**Consultation Response from KC,
Highways Development Management**

2025/90261 York House, 198, Barnsley Road, Denby Dale, Huddersfield, HD8 8TS

Reserved matters application pursuant to outline permission 2022/91024 for demolition of existing works and erection of residential development (3 detached dwellings)

Date Responded: 11/03/25

**1 PROPOSED SITE PLAN**  
 1 : 125

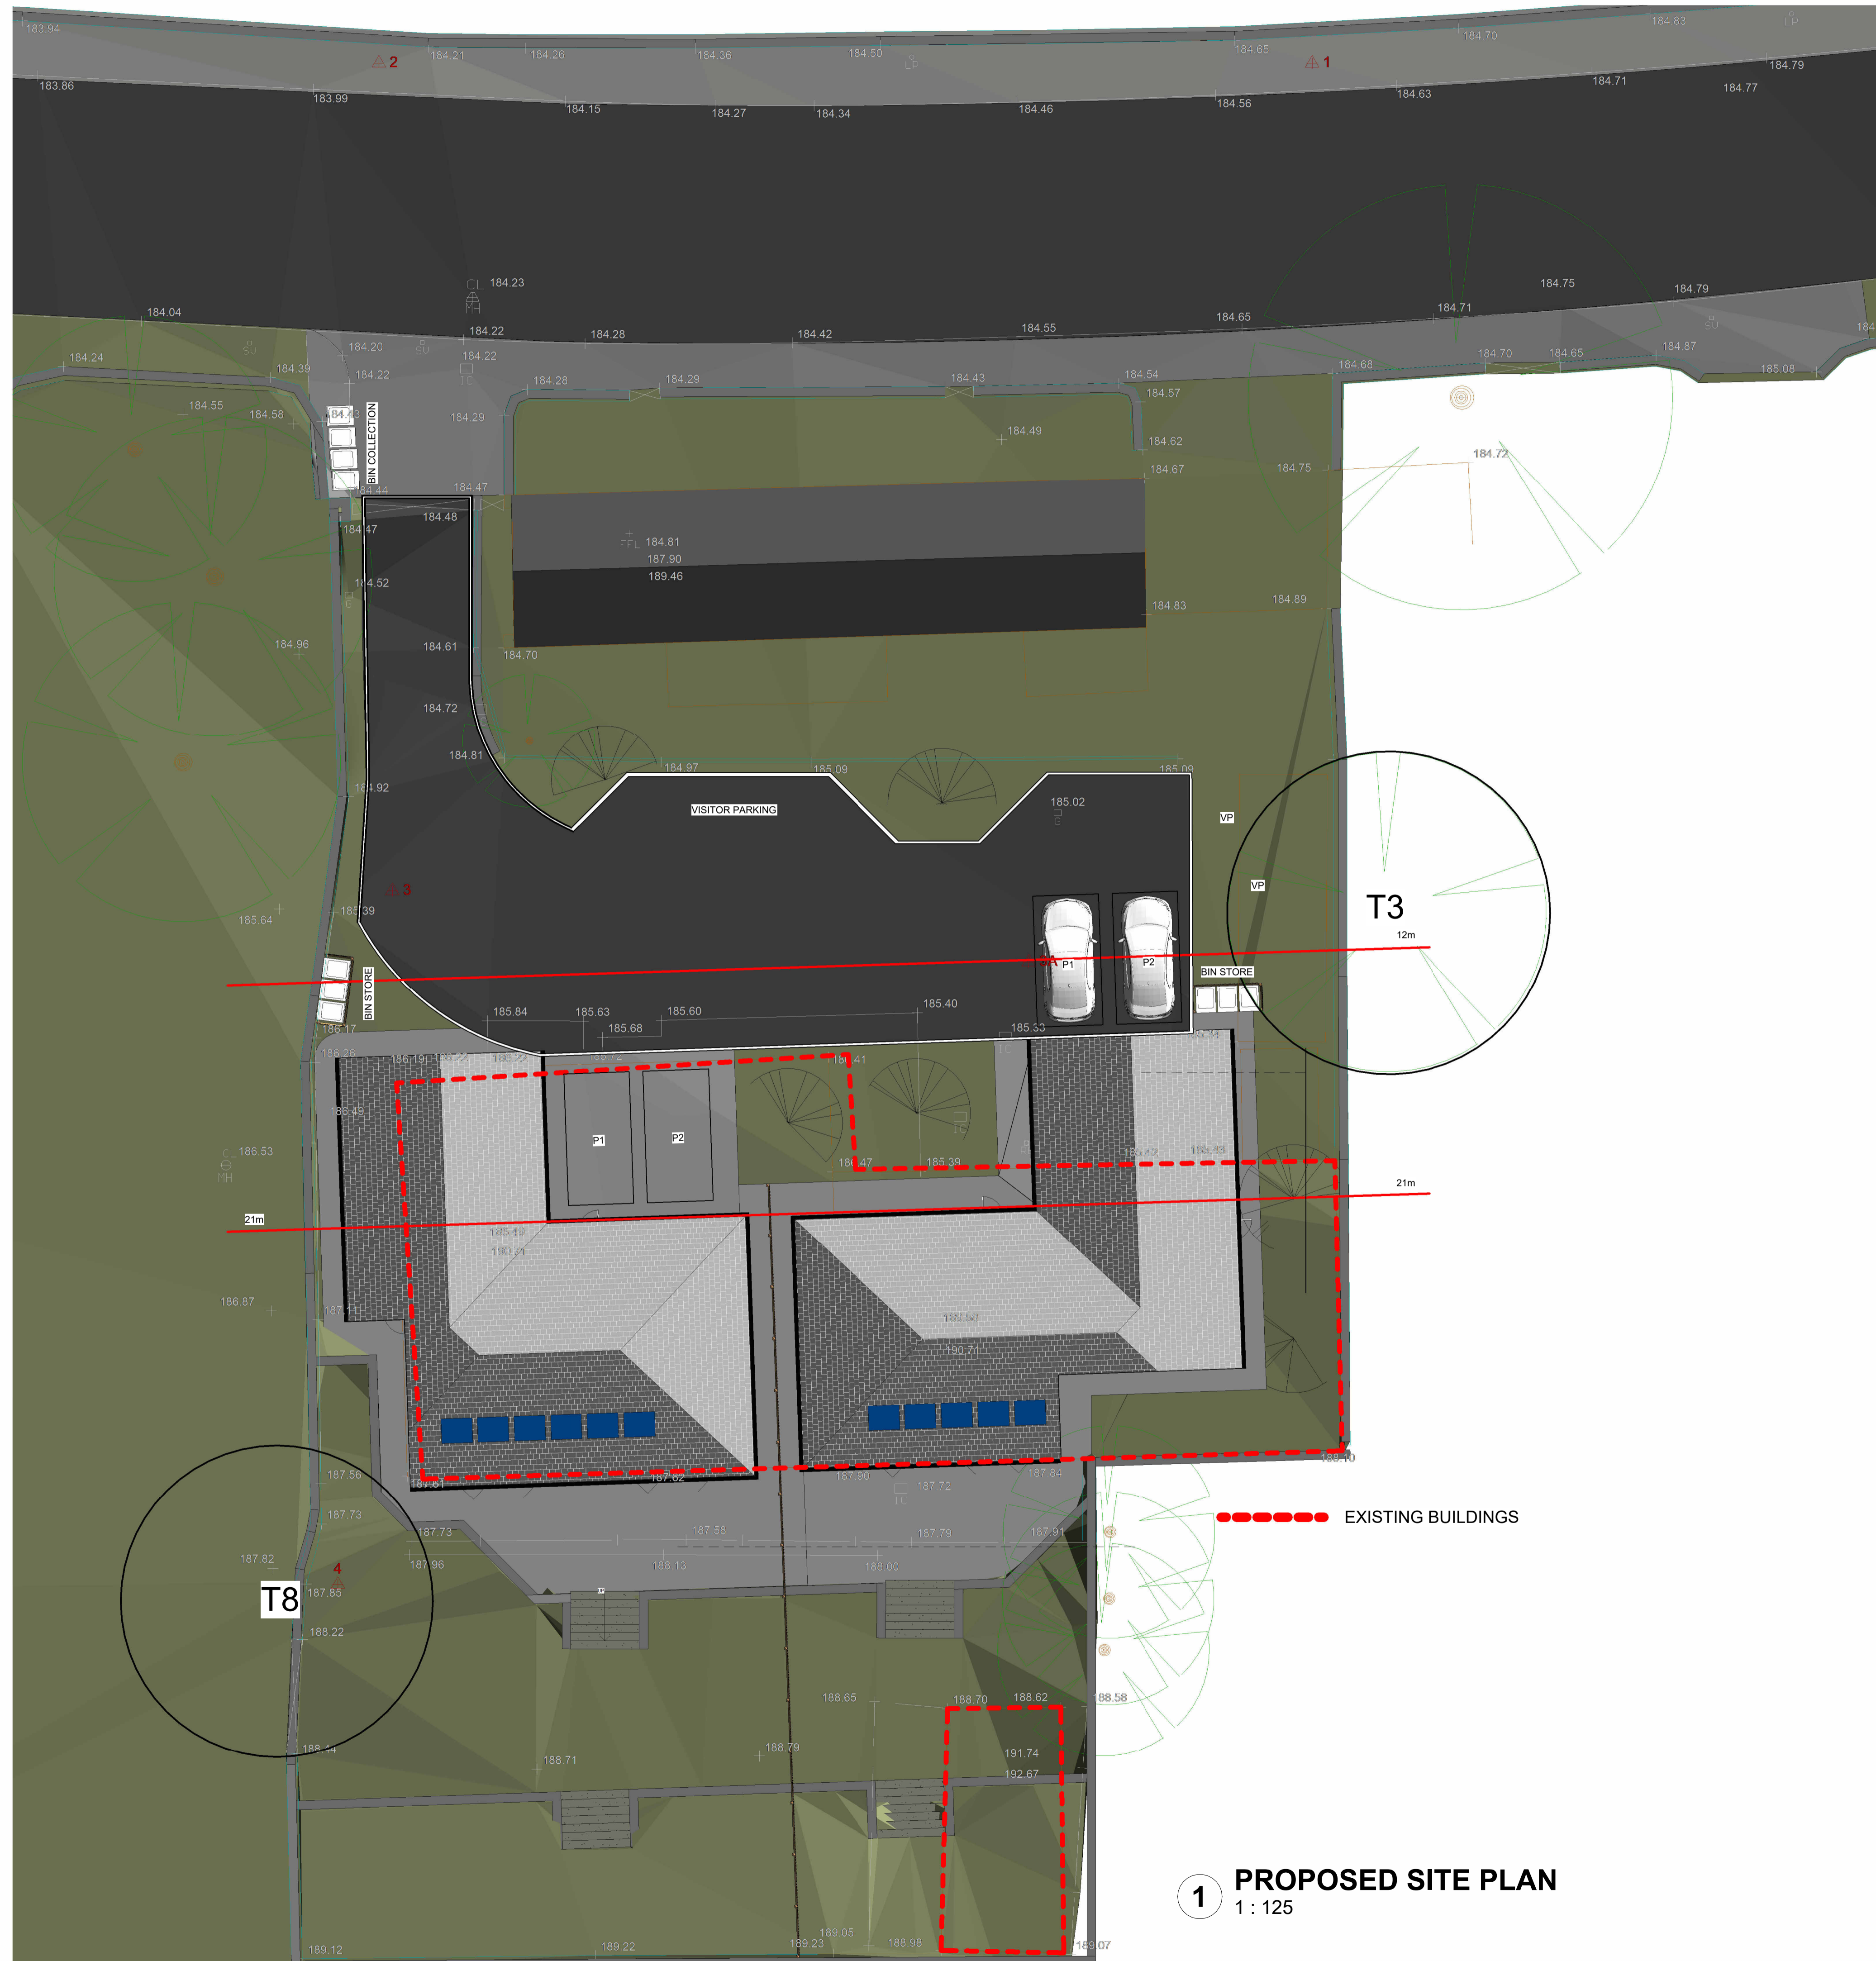
The proposals are for a 3 dwelling residential development from an approved access as shown on drawing No (100)02. This drawing shows the access is to be gated and the gate is set back from the edge of the existing highway by approximately 5.5m and this would be acceptable for a car to be able to clear the highway whilst waiting for the gate to be opened. The gate should be set to open inwards only, and this should be included within a condition.

There is a driveway shown on drawing No (100)02 that would provide turning for vehicles within the site so they can enter and exit the site in forward gear. This should be clearly marked on the drawing as a turning area and should be kept clear to allow turning of vehicles for the lifetime of the development. This should be conditioned.

As the site is not expected to be offered up for adoption and remain a private driveway, we would not expect a waste collection vehicle to enter the development and so collection would be made from the adopted highway. Drawing No (100)02 shows a bin collection presentation point, however this is approximately 8m from the edge of the adopted highway and is behind a gate. The collection point should be located in such a place that it is easily accessible to a collection team and this should be conditioned. Guidance on waste storage and collection for new developments can be obtained from the Kirklees Waste Strategy Team and can be found at <https://www.kirklees.gov.uk/beta/planning-applications/pdf/waste-management-design-guide-new-developments.pdf>

Notwithstanding the provisions of the Town and Country Planning (General Permitted Development) Order 1995, (or any order revoking and re-enacting that order) any gates or barriers for or over a vehicular access or egress shall be set back approximately 6m from the back of the carriageway as shown on drawing No (100)02 and shall be hung as to only open inwards. So long as such gates or barriers are in position they shall be retained to only open inwards.

Before any dwelling is occupied, a turning area shall be clearly marked on drawing No (100)02 and then be provided in accordance with the details shown the approved drawing. The turning facilities shall thereafter be made available for use at all times by vehicles and shall be kept free from obstruction to such use.

Before development commences, details of suitable storage, bin presentation points and access for collection of wastes from the dwellings hereby approved shall be submitted to and approved in writing by the Local Planning Authority. The approved details shall be provided before first occupation and shall be so retained thereafter.
